TO: Inspections

FROM: Jay Reynolds, Development Review Coordinator

DATE: April 20, 2001

RE: C. of O. for # 75A, 75B, 77 Maggie Lane (341-A-022)

Ordering Name:
Grading & Drainage - Lot 12
Project:
MAGGIE LANE, PORTLAND

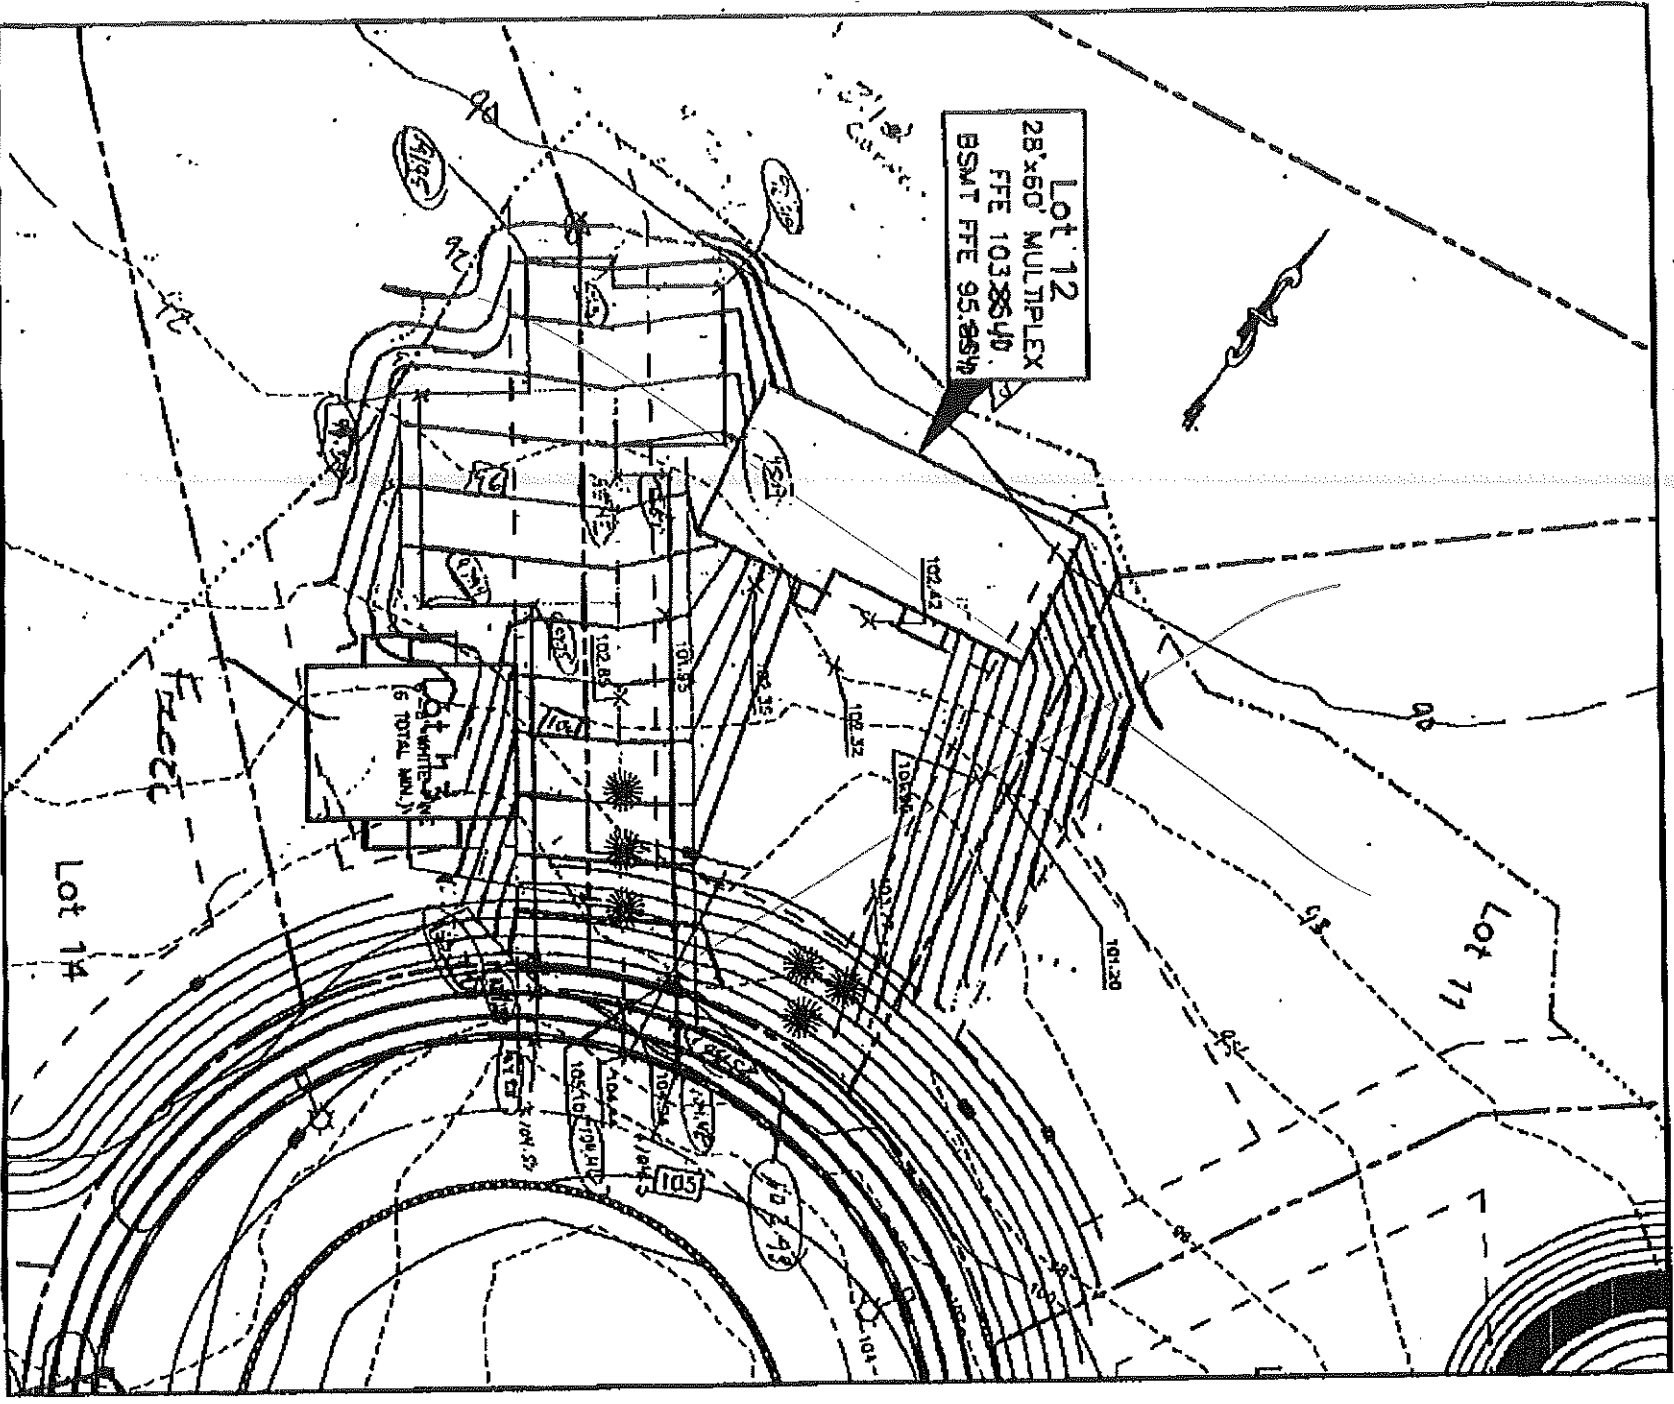
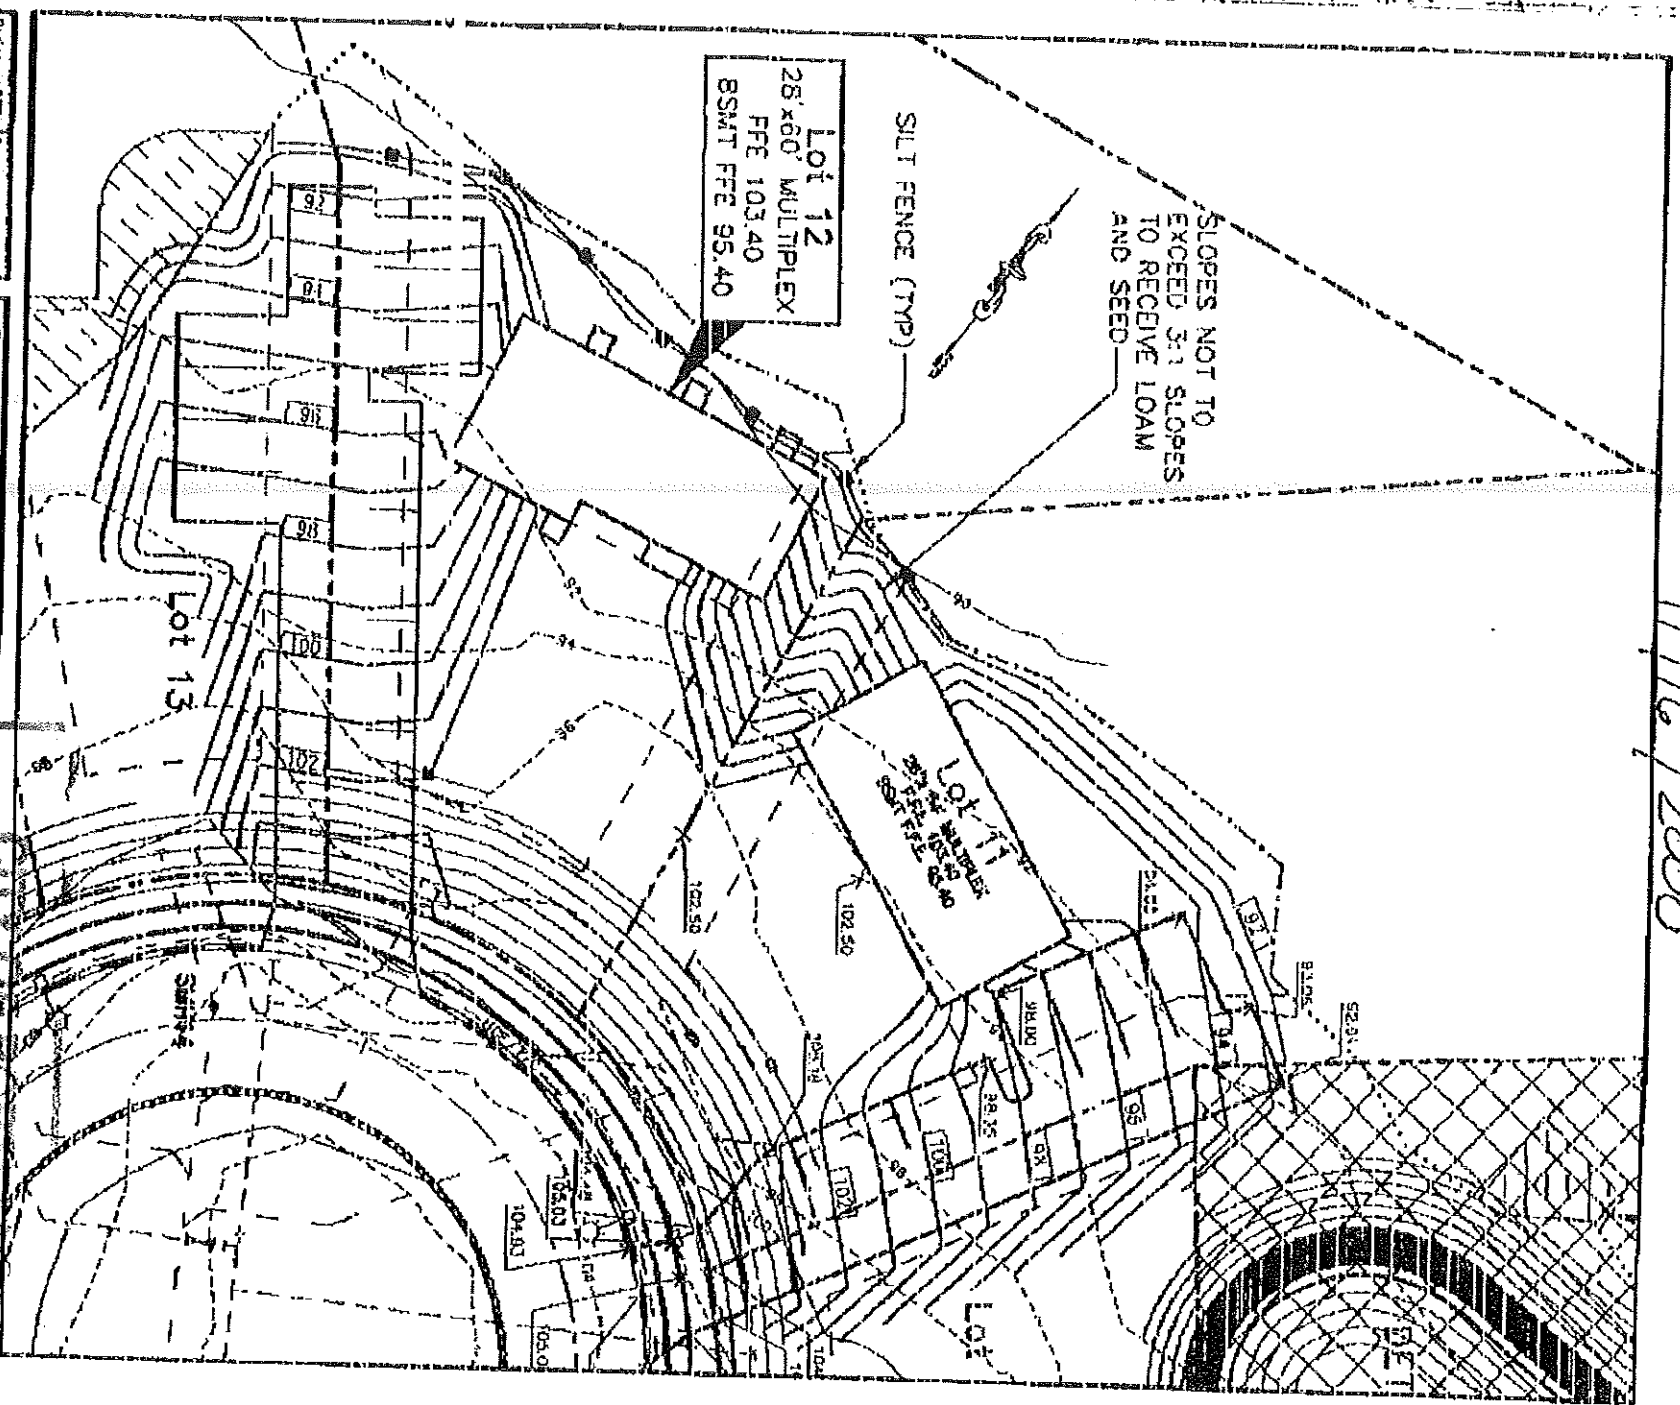
1. Landscaping Incomplete.
2. Grass catch incomplete.
3. The driveway is not paved.
4. Grading/elevation changes pertaining to the common driveway need to be addressed (proposed grades do not coincide with approved plan; considerable change in design). Awaiting revised plan from applicant.
